**From:** "Shelley" <sales@bluecolddistributors.com>  
**To:** "Building Inspections" <buildinginspections@portlandmaine.gov>  
**Date:** 12/11/2013 10:15 AM  
**Subject:** 545 Congress St. Addendum  
**Attachments:** 545 congress st fan view (1).pdf

545  
Congress  
1/B

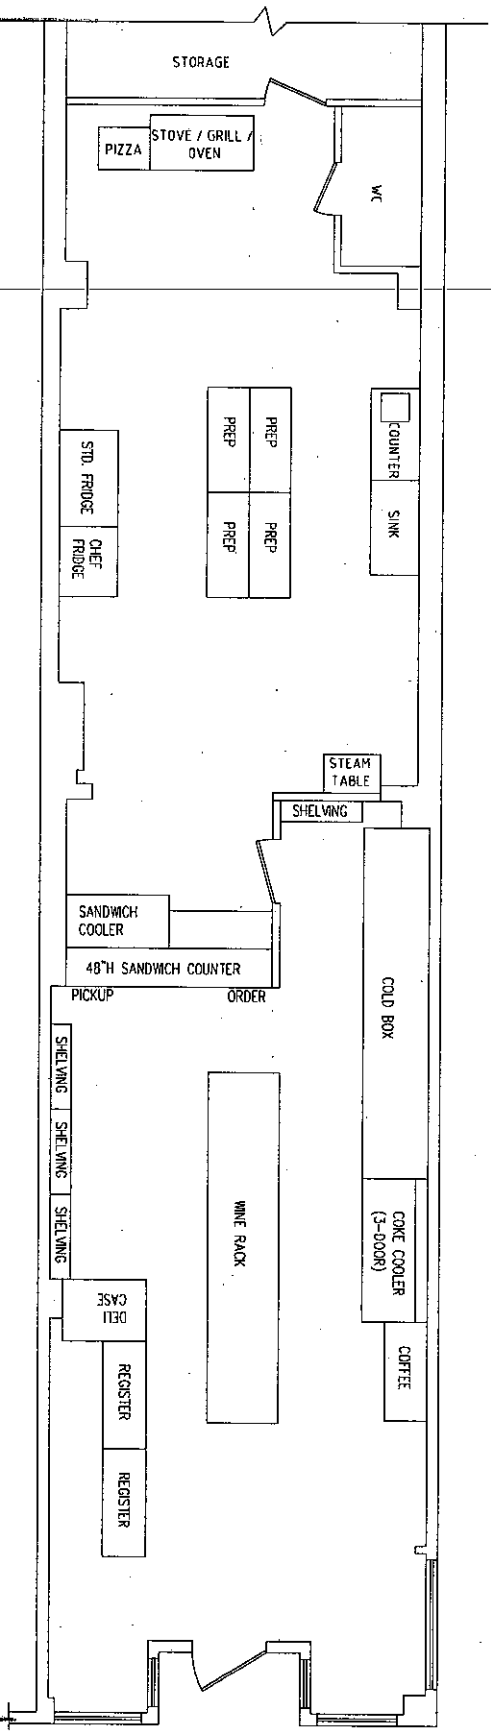
Rob Weiner from historical is requesting this additional information:  
New fan to be mounted left of the existing fan which will give us the 10' and 12' from the left end of building. Fan height to be 5'.
